Date: 24 October 2025  
Our ref: 530814  
Your ref: EN010130

**Planning Act 2008 and The Infrastructure Planning (Examination Procedure) Rules 2010  
Application by Outer Dowsing Offshore Wind Farm Limited ("the Applicant") for an Order  
granting Development Consent for the proposed Outer Dowsing Offshore Wind Farm  
("Project")**

The following constitutes Natural England's formal statutory response to the Secretary of State's Request for Further Information (RFI) dated 10 October 2025 Part A.

Figure 1: [Habitat suitability for \*Sabellaria spinulosa\* reef within the Outer Dowsing Offshore Windfarm Export Cable Corridor \(ECC\) and Inner Dowsing, Race Bank and North Ridge Special Area of Conservation \(IDRBNR SAC\).](#)

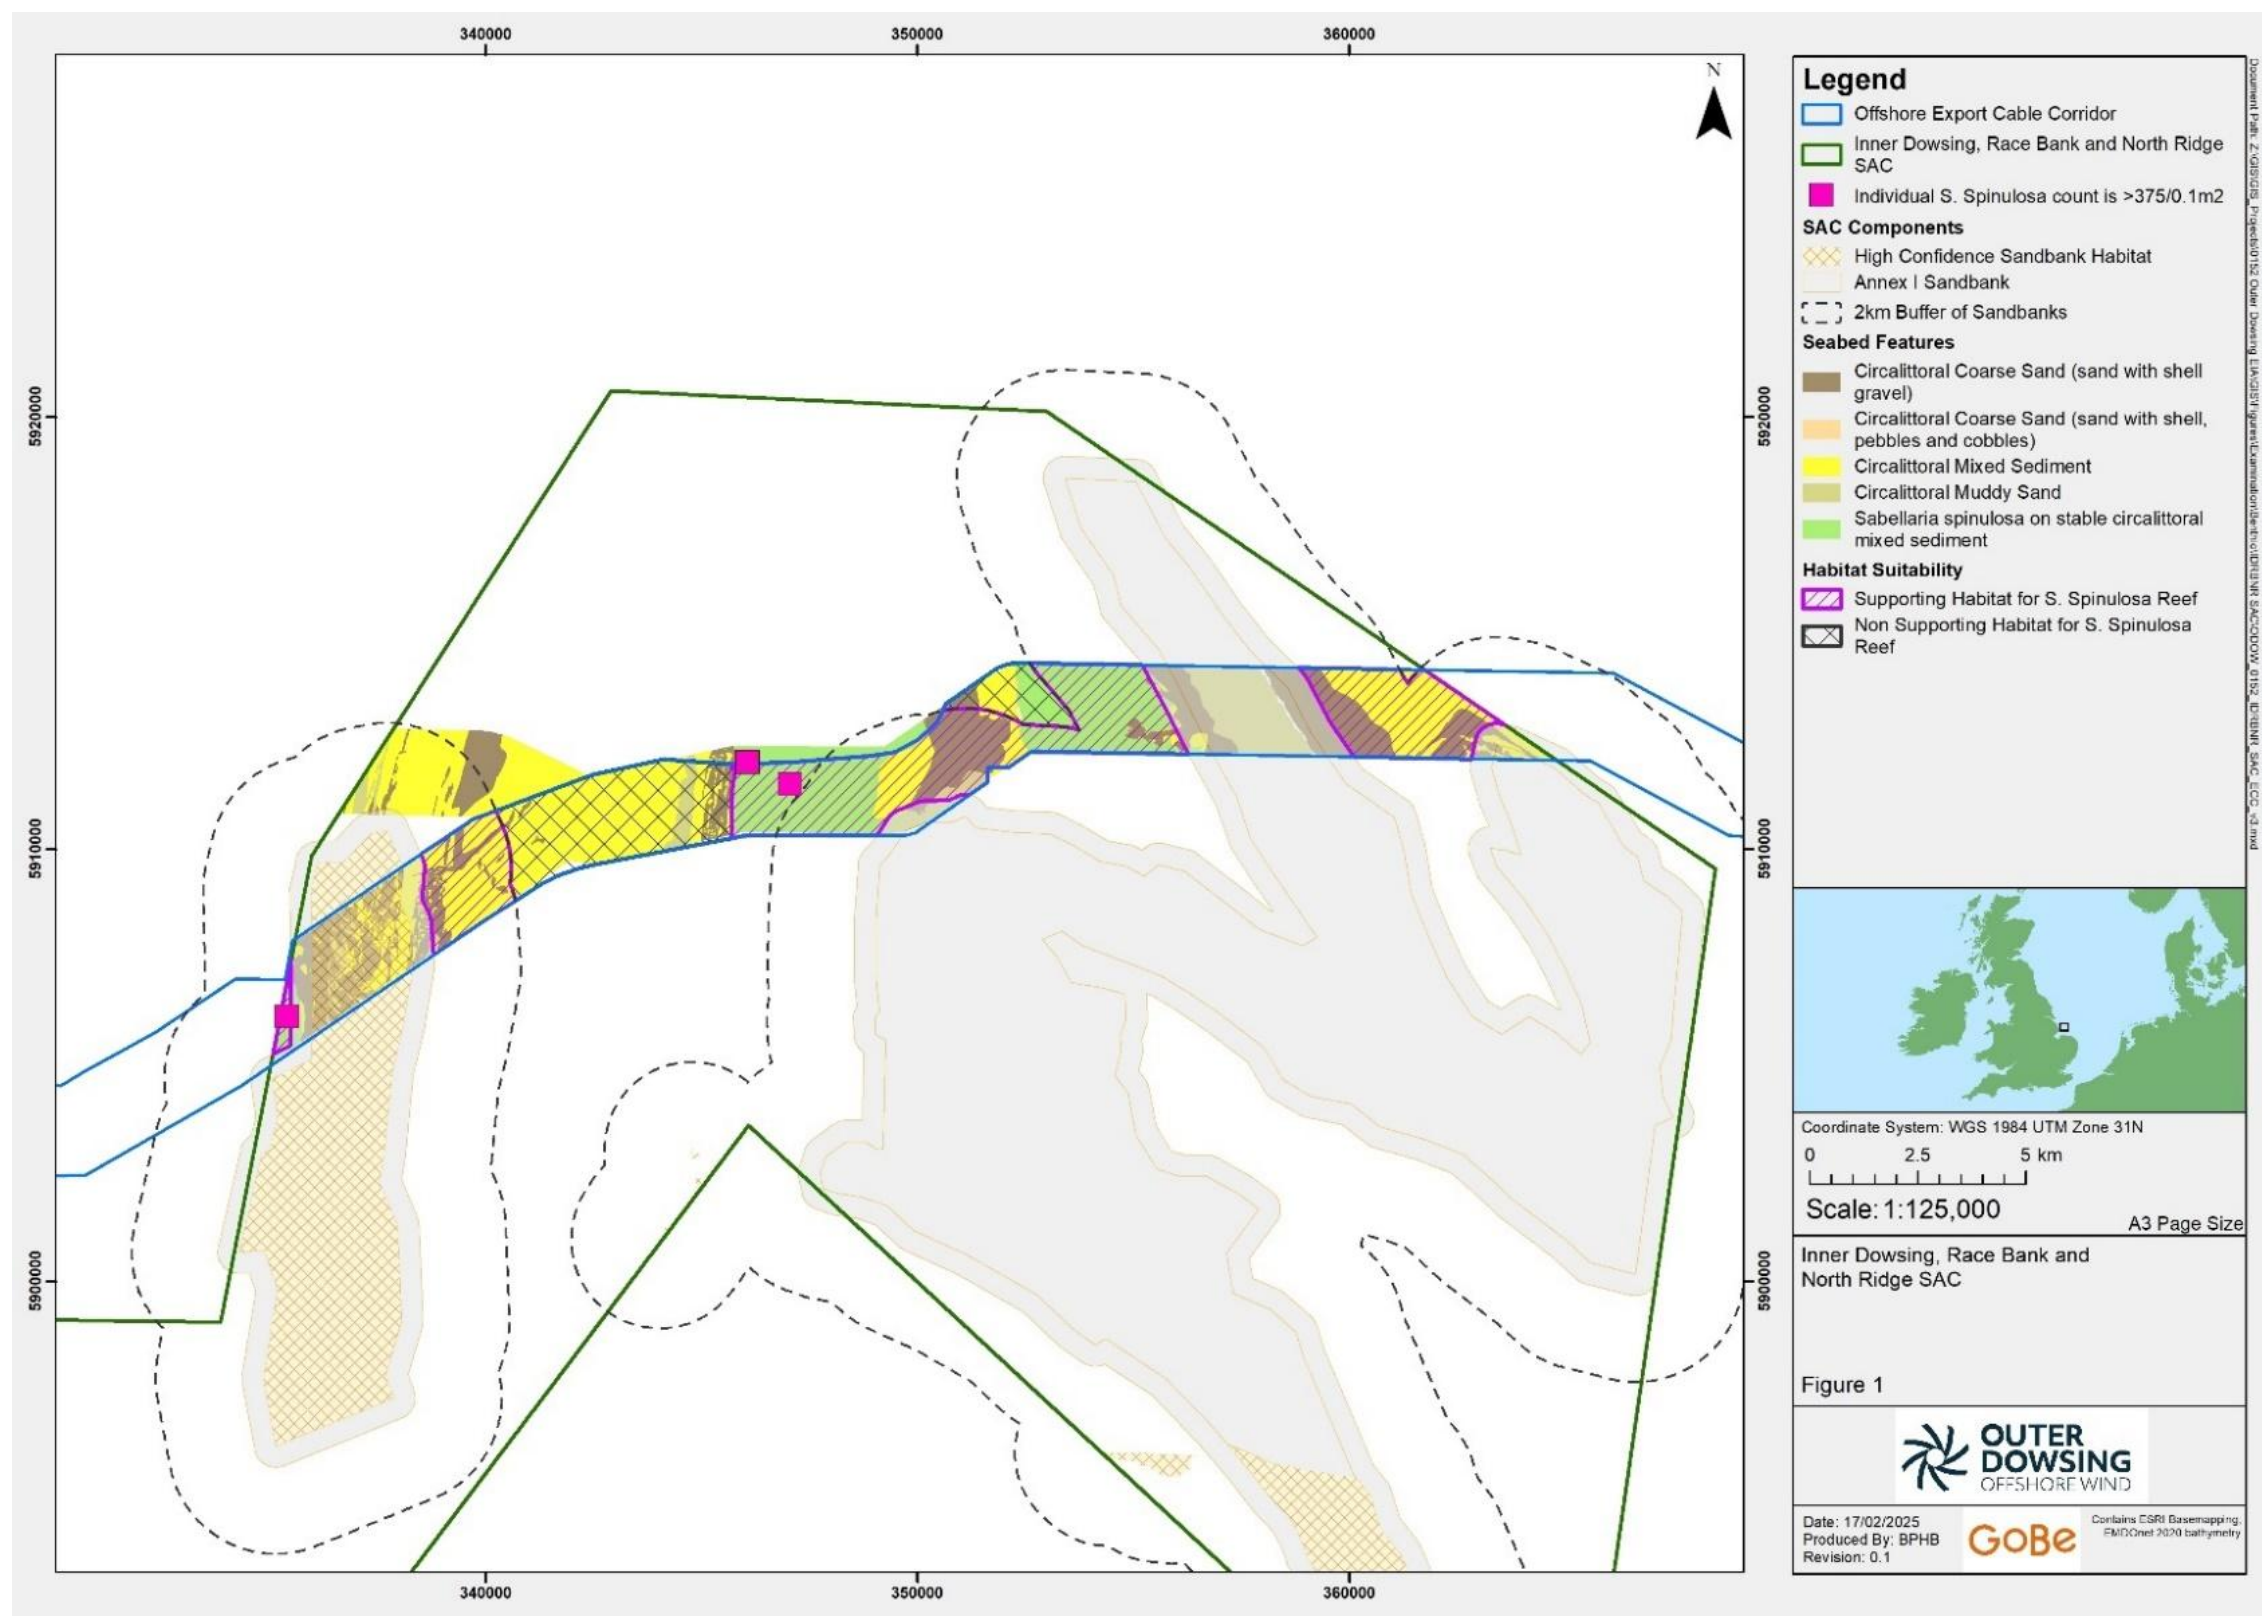
- Any cable protection required over the Annex I Sandbank feature within the Inner Dowsing, Race Bank and North Ridge IDRBNR SAC will be removable (i.e. mattresses or rock bags or other demonstrably removable protection).
- Any cable protection required on defined areas of supporting habitat for the Annex I *Sabellaria spinulosa* reef within the IDRBNR SAC, shown on Figure 1, will be removable.
